CITY OF ALBUQUERQUE

July 7, 2022

**Re: Volcano Mesa Subdivision
Erosion and Sediment Control Plan
Engineer's Stamp Date: 6/27/2022 (C09E001H)**

Temporary Erosion and Sediment Control Plan

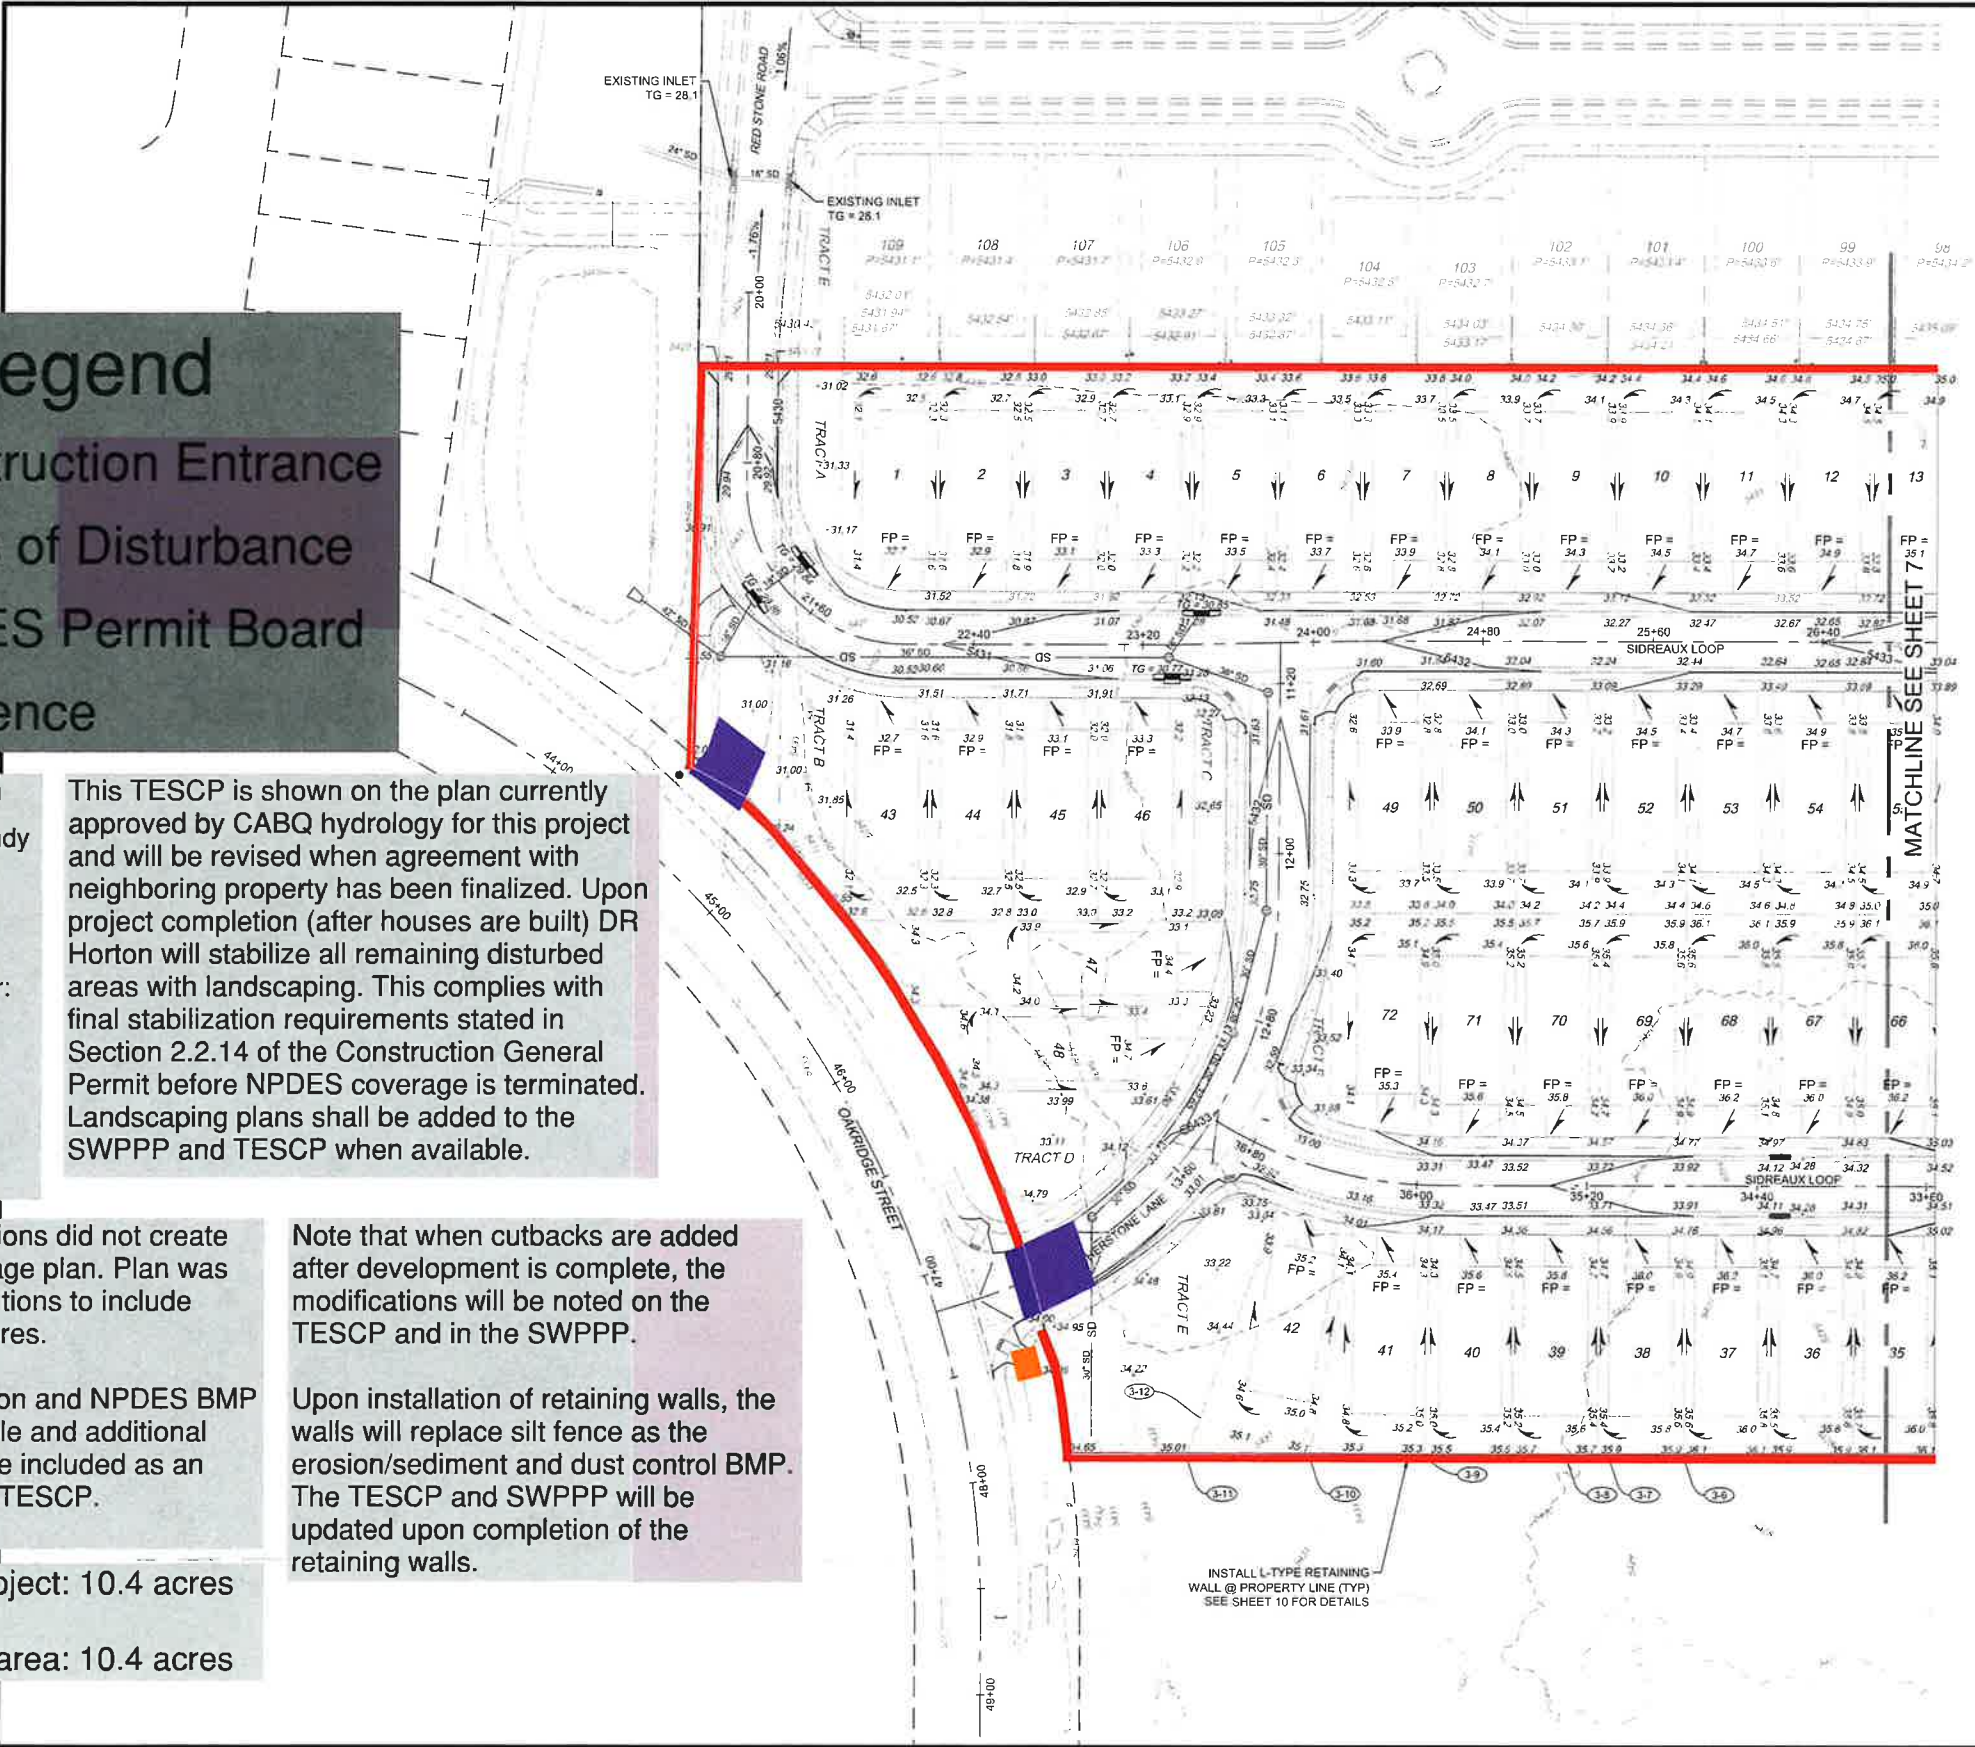
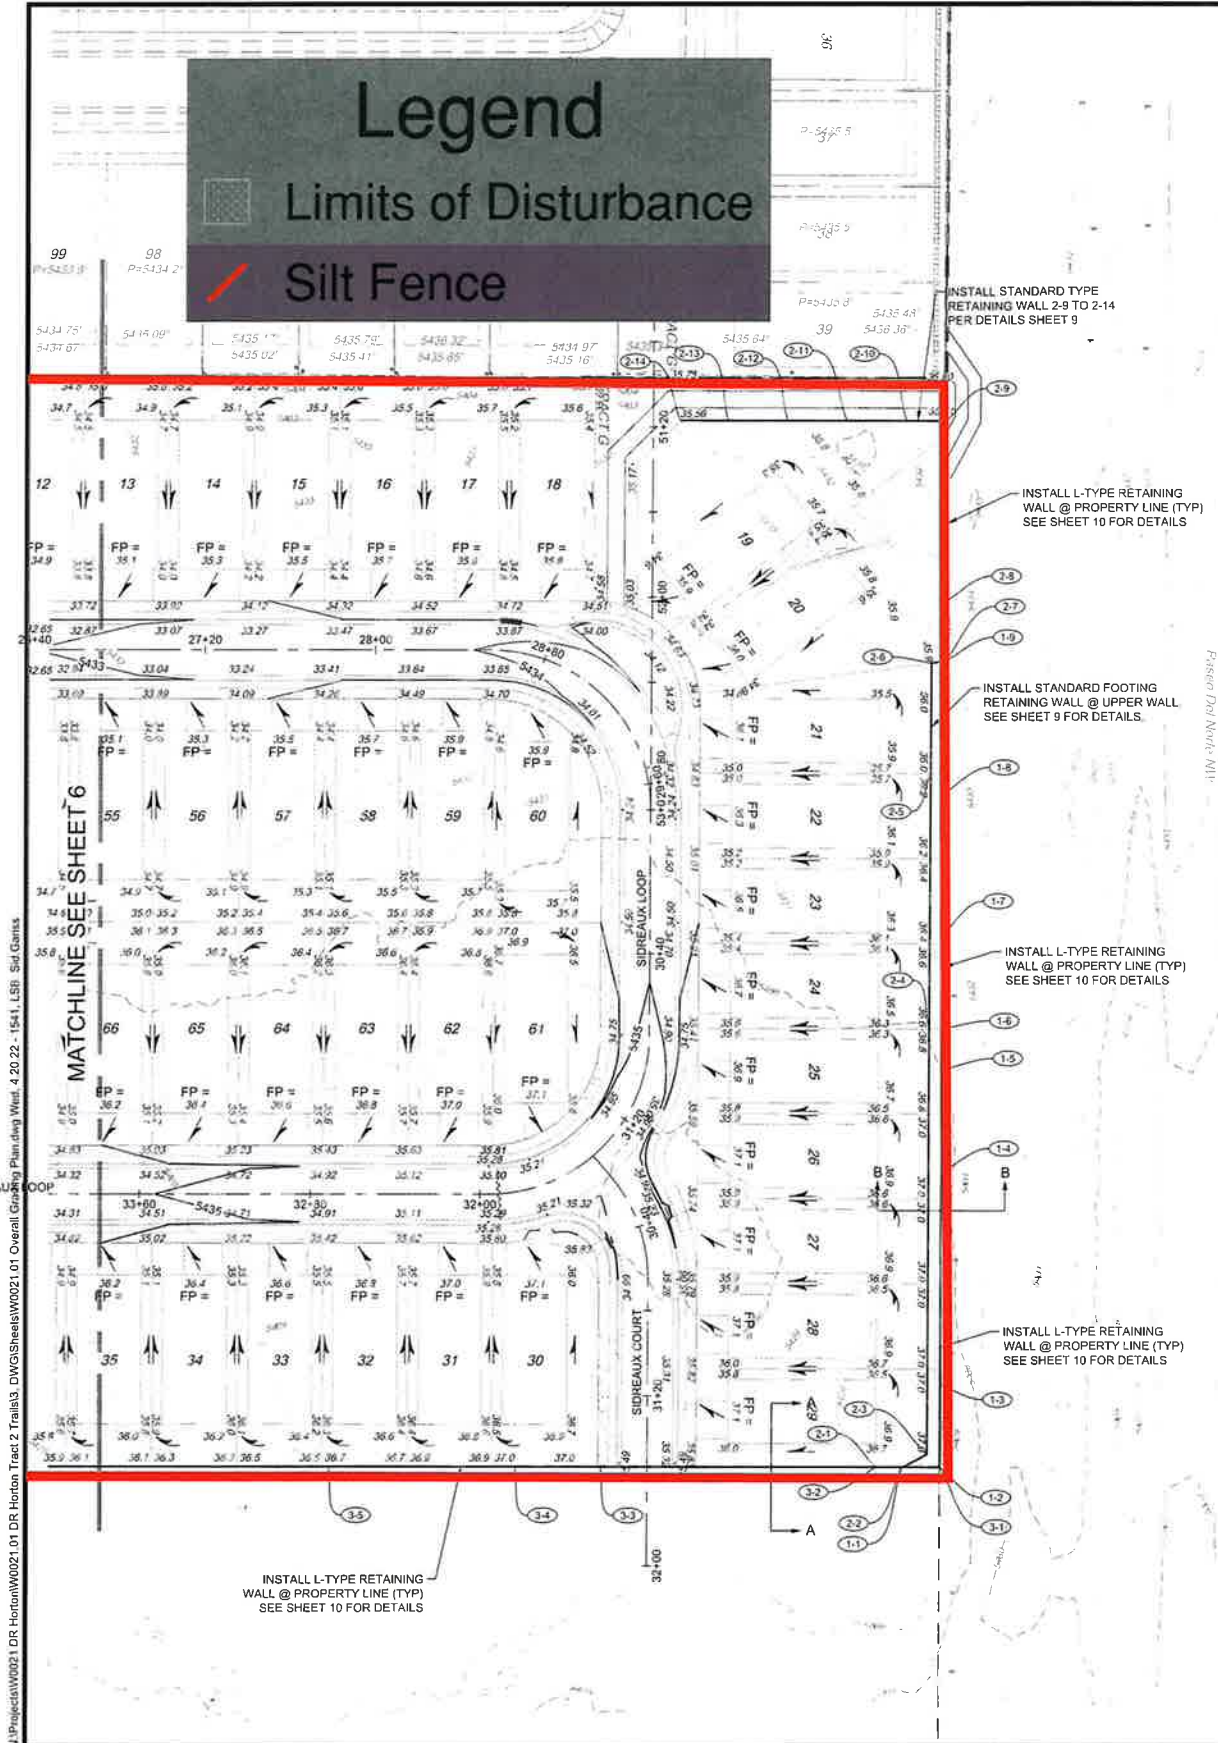
1. The actual location of Cutback Swales and Inlet Protection must be shown on the ESC Plan along the frontage of the lots for Building Permit (BP) approval, not just a general note. These BMPs should be established by the developer near the end of the grading and construction of the public infrastructure, then it should be maintained during Build Permit by the home builder.
2. How will the HOA Tracts be stabilized? Will they be Stabilized by DR Horton or the HOA? Please provide landscape plans and specification if available and include them in the SWPPP (CGP 7.2.6.b.vi and 9.4.1.c.i).
